COUNCIL REFERENCE: 3A10/1003  
CONTACT PERSON: Elizabeth Downing

1 September 2017

**West Culburra Mixed Use Subdivision - SSD 3846  
West Culburra Concept Plan  
Supplementary Response to Submissions**

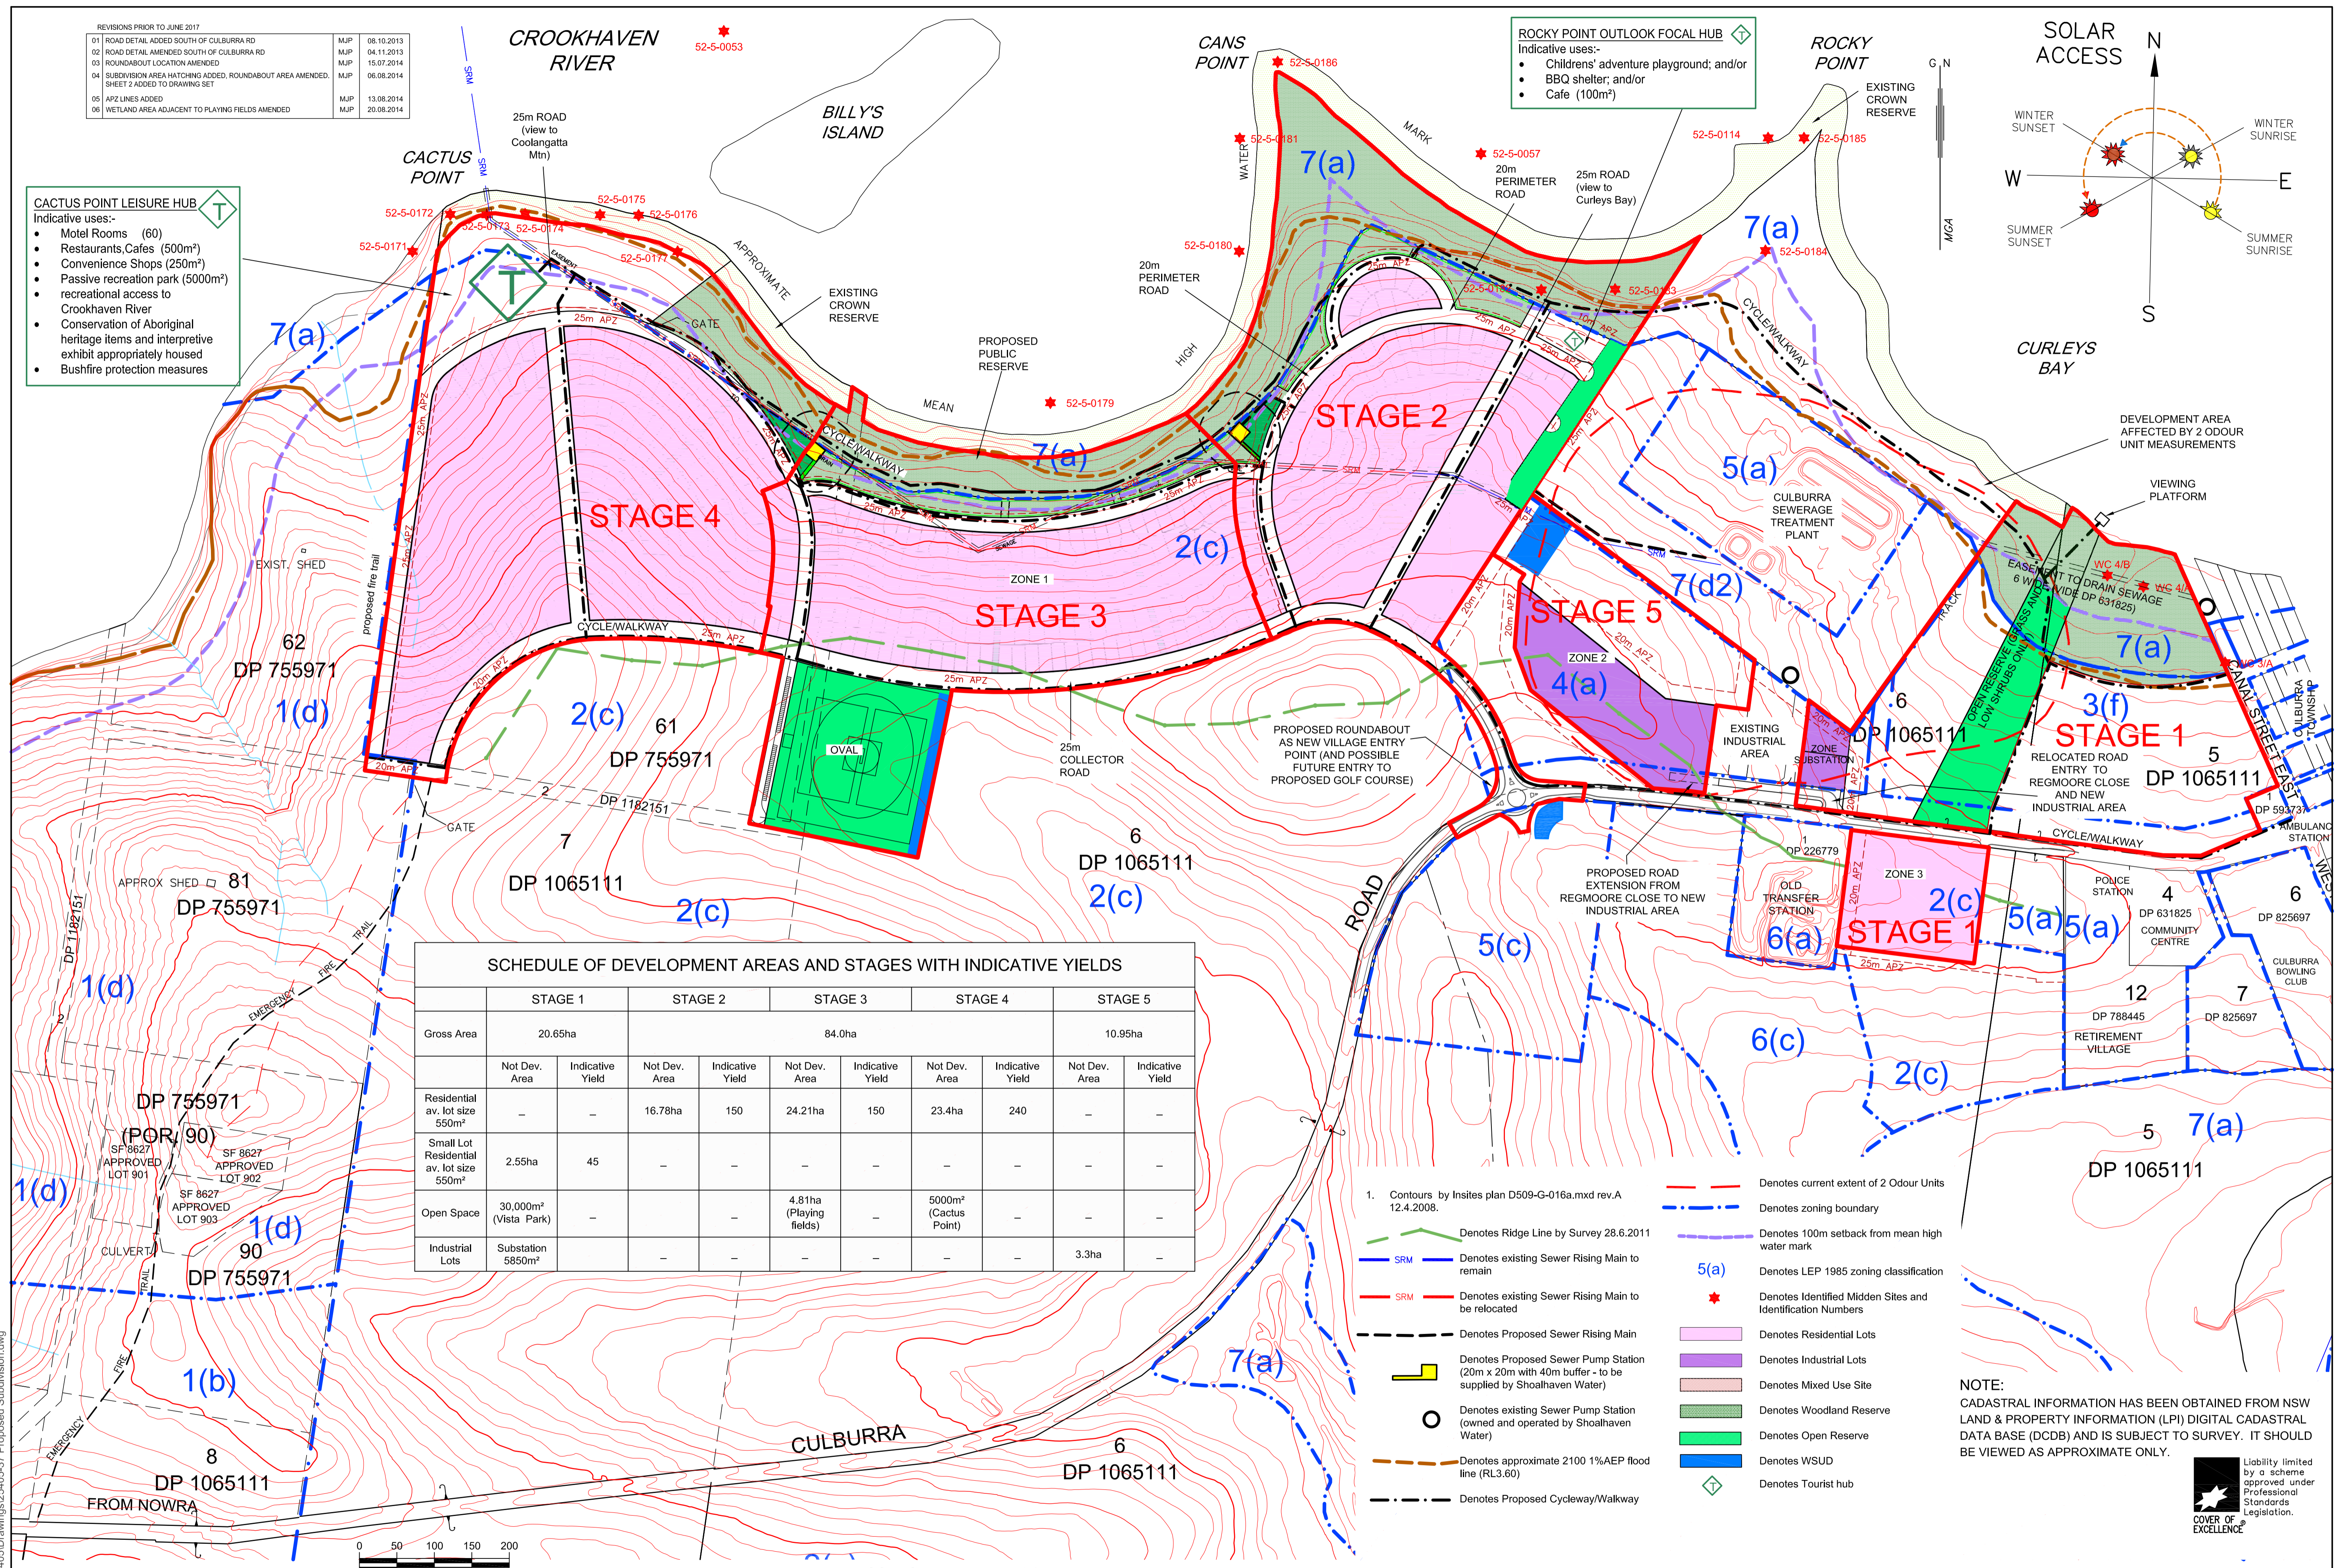
The concept plan has generally been corrected to reflect the application being a concept approval rather than a subdivision. However, there are a number of inconsistencies on the plan in its amended form. In particular:

- The legend refers to "residential lots", "industrial lots" etc. There are no new lots proposed in this application and so these should be amended "residential areas", "industrial areas" and so on. Additionally, there is still a legend entry for "mixed use site" even though there are no mixed use sites proposed.

- The plan includes 2 tables titled "Areas". The first (left hand side) refers to stages that are not otherwise represented on the concept plan. These stages should be overlaid on this plan to make clear the order in which the development is to be undertaken. All other area identifiers ("area", "zone" etc) that relate to staging should be removed to avoid confusion.

- The second (right hand side) table titled "Areas" relates to reserves. We consider that this table can be deleted if the Yield table is appropriately updated.

- The plan includes a table titled "Yield". That table refers to numbers of lots including mixed use sites that, according to the RTS, are no longer proposed.

- The table "Yield" refers to numbers of residential lots but not numbers of dwellings or lots for medium density or tourist sites. This is an inconsistency that should be corrected to reflect that the proposal is now a concept plan and not a subdivision. We consider it appropriate for the table to be structured as shown below (numbers are fictitious):

The revised concept plan retains the proposed removal of vegetation within the 7(a) zone under LEP 1985 to create view corridors for the development. This clearing is inconsistent with the objectives of the 7(a) zone, specifically:

It is considered that the amenity benefits from this clearing are not sufficient to justify the loss of environmental land and the fragmentation of this environment. These view corridors should be deleted from the concept plan.

It is considered appropriate to require the deletion of this site from the concept plan.

Council's Community Infrastructure Strategic Plan provides that a local recreation park should be provided in accordance with Appendix E to that plan. It is considered that this should be planned for at the concept approval stage and the concept plan should be amended to show a suitable location for this piece of infrastructure.

This is a matter that is best addressed in the concept planning stage for the land. It is submitted that the applicant should be required to amend the plan to identify an area for aged care facilities with an anticipated yield in population (persons).

The amenity benefits from the proposed view corridors are not sufficient to justify the loss of environmental land and the fragmentation of this environment. These view corridors should be deleted from the concept plan.

It is submitted that there is too much detail on the concept plan for the proposed T1 tourism development. The current plan appears to show significant public open space and an internal road layout. This is premature given the limited information currently available. It is submitted that this precinct should instead be identified as a single coloured polygon with no internal road layout with a specification as to what development is intended to be accommodated in that area.

It is recommended that this be removed from the concept plan.

- a) Between the residential land (formerly "The Circus" precinct) and the adjacent 4(a) and 7(d2) zoned land to the east.
- b) Along the western boundary of the development
- c) Along the southern boundary of the development in the south western corner of the land.

These perimeter roads should be secured at the concept plan stage and the plan should be amended in show them.

As previously noted in Council's 2013 submission, it is considered that the bus route should be extended to the proposed T1 tourism development. It is recommended that the concept plan be amended to nominate a suitable bus route.
